GOVERNMENT ARCHITECT NEW SOUTH WALES

30 September 2021

PROJECT: Northside Clinic Wentworthville
RE: State Design Review Panel (SDRP) – 15 September 2021 (First
Review)

Figure 13 Shadow Diagrams during winter solstice (Team 2 Architects 2021)

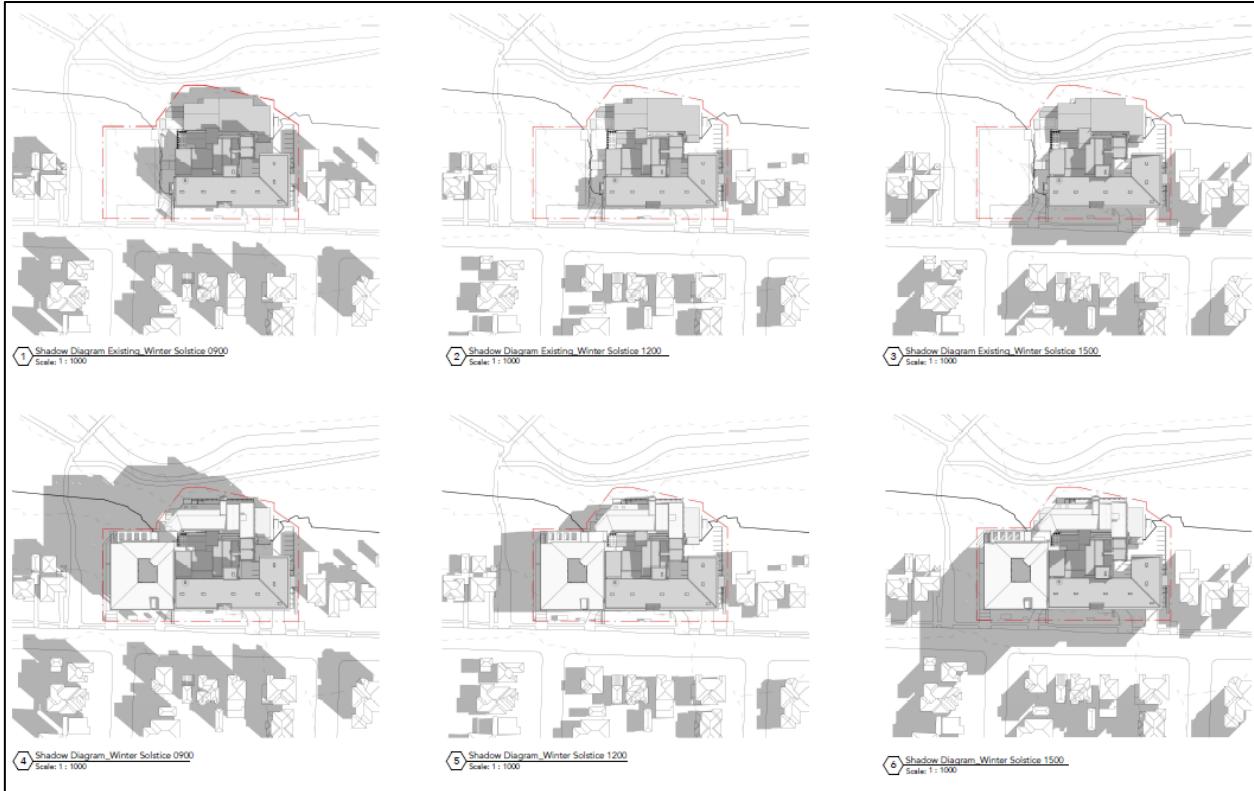
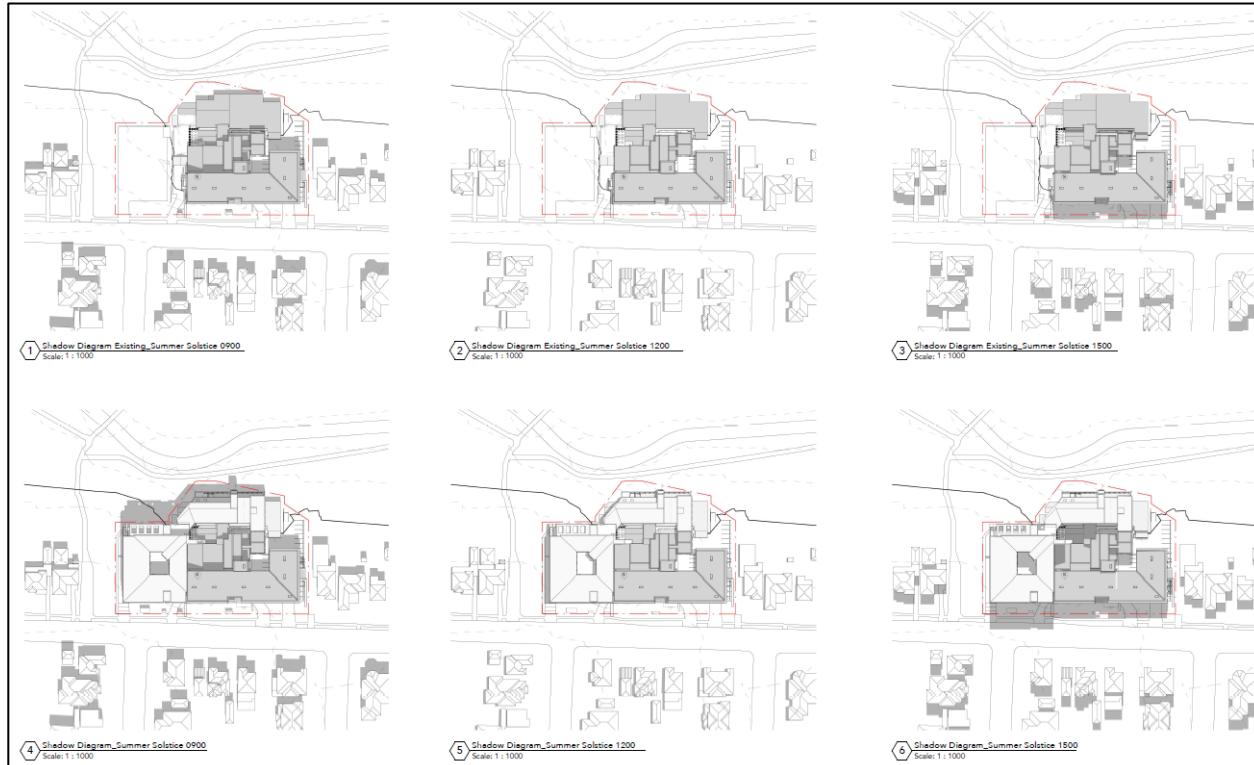
8. The residential property to the south is overshadowed, which requires mitigation as described above. For future presentations, clarify the shadows produced by buildings by removing the trees from the shadow diagrams.
